**Application no: 24/00245/OUT**

**Location:** South Lodge, Fringford Road, Caversfield, Bicester, OX27 8TH

## Transport Schedule

Figure 3.2 – Walk Distances

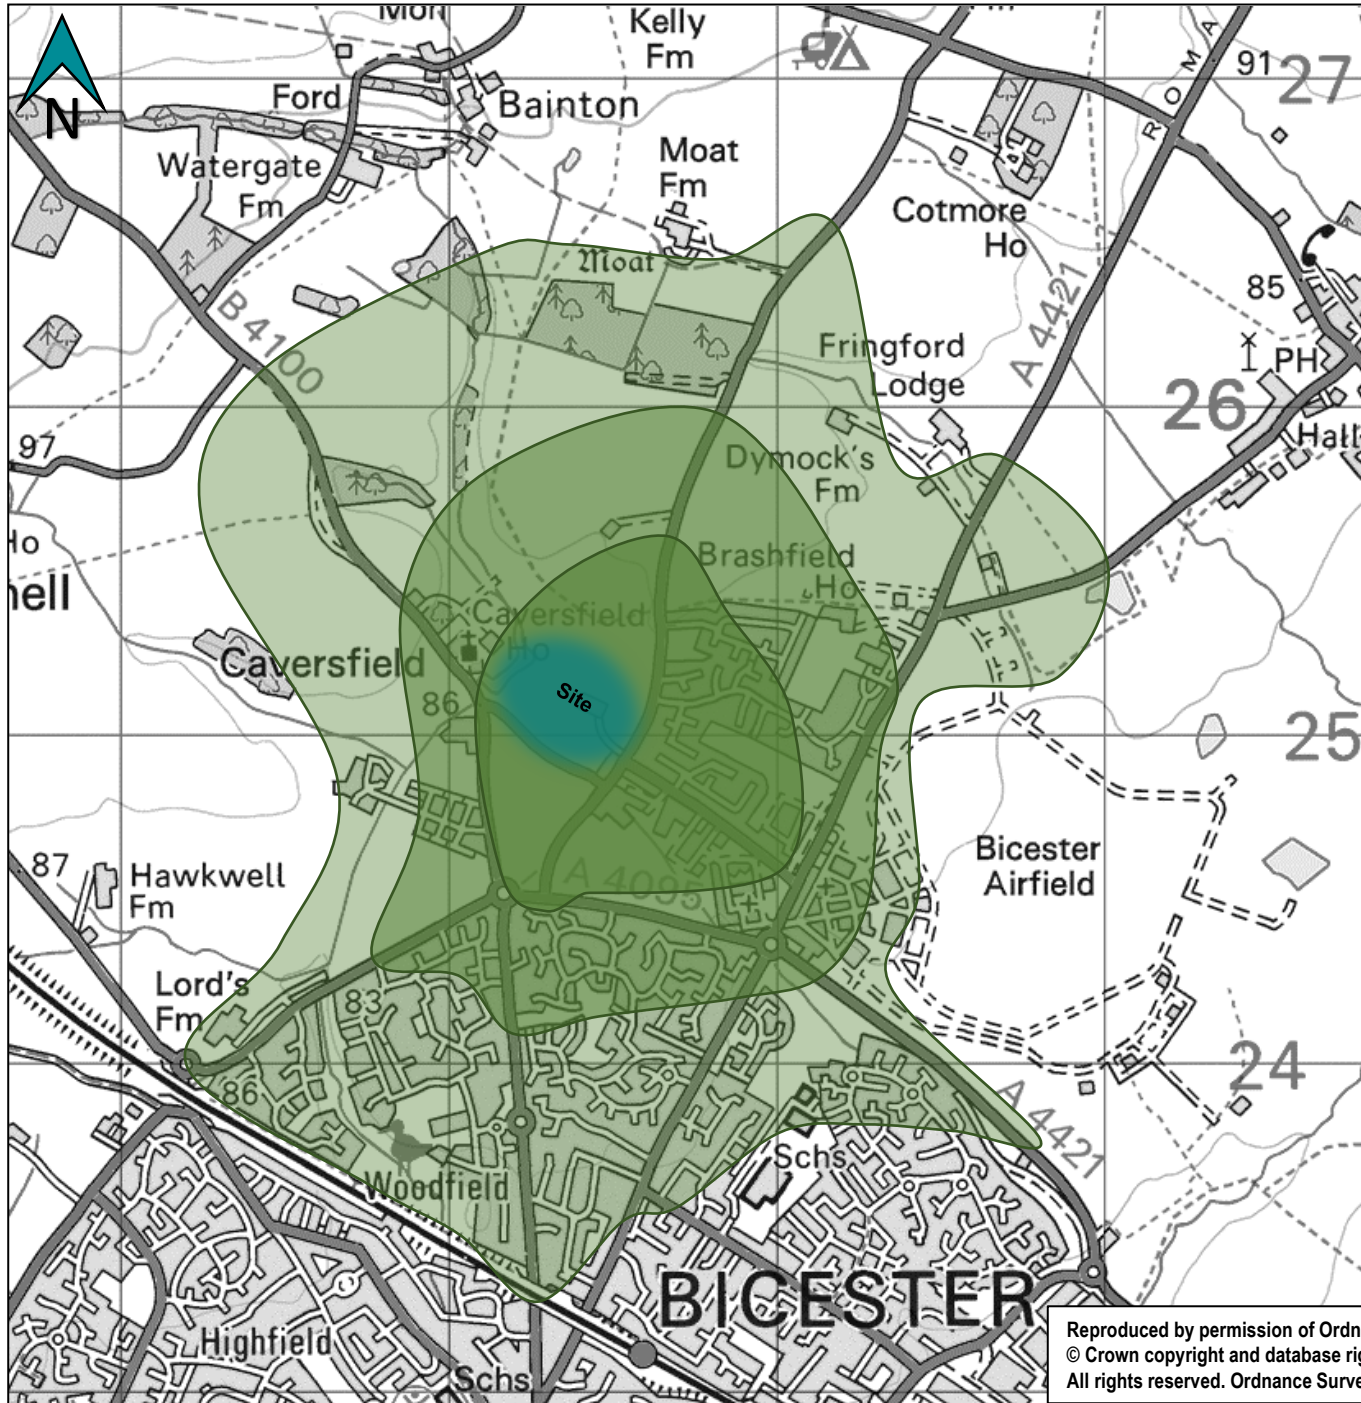
Table 3 shows the distances from the site to local facilities that are expected to be commonly used by residents of the proposed site. The TA does not disclose the exact point the distances have been measured from and therefore it cannot be accurately determined whether these amenities are conveniently accessible by residents on foot. The centre of development is considered an acceptable measurement point in this case. It can be determined however that from the measured location, no food shopping facilities are within the preferred maximum distance within the IHT guidelines.

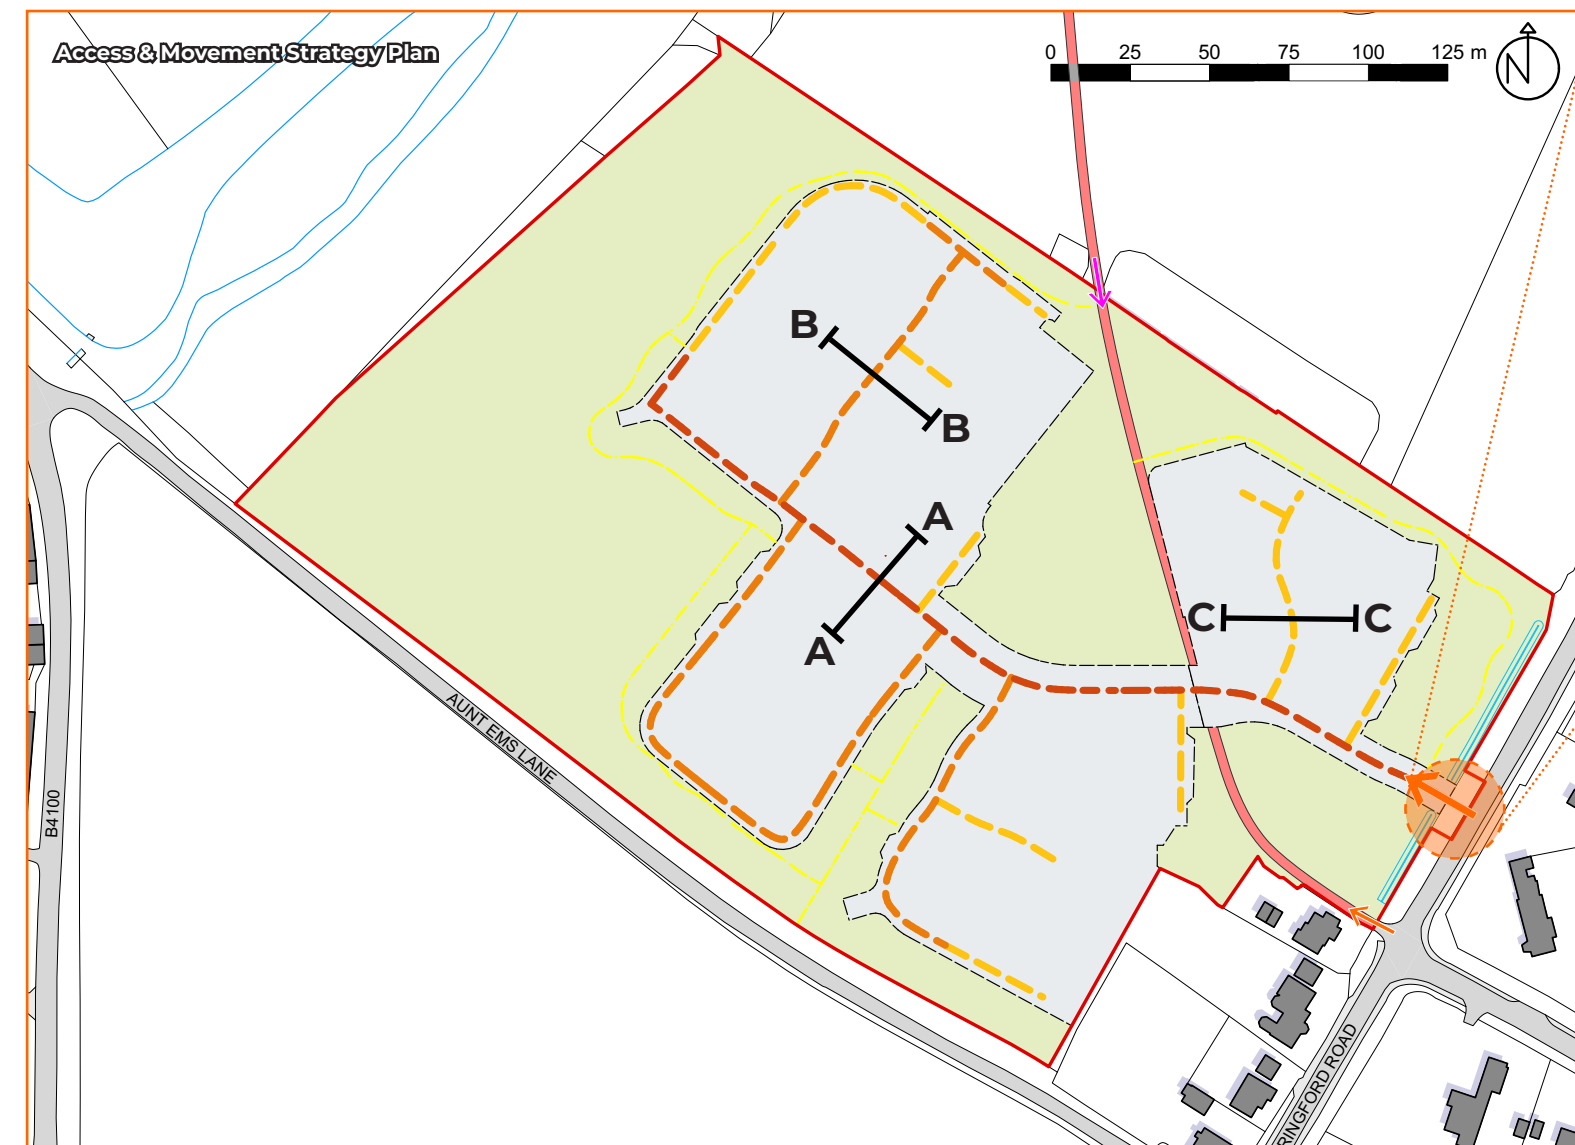
Footpaths throughout the development do not seem to be continuous and seem to finish abruptly, especially at the side roads.
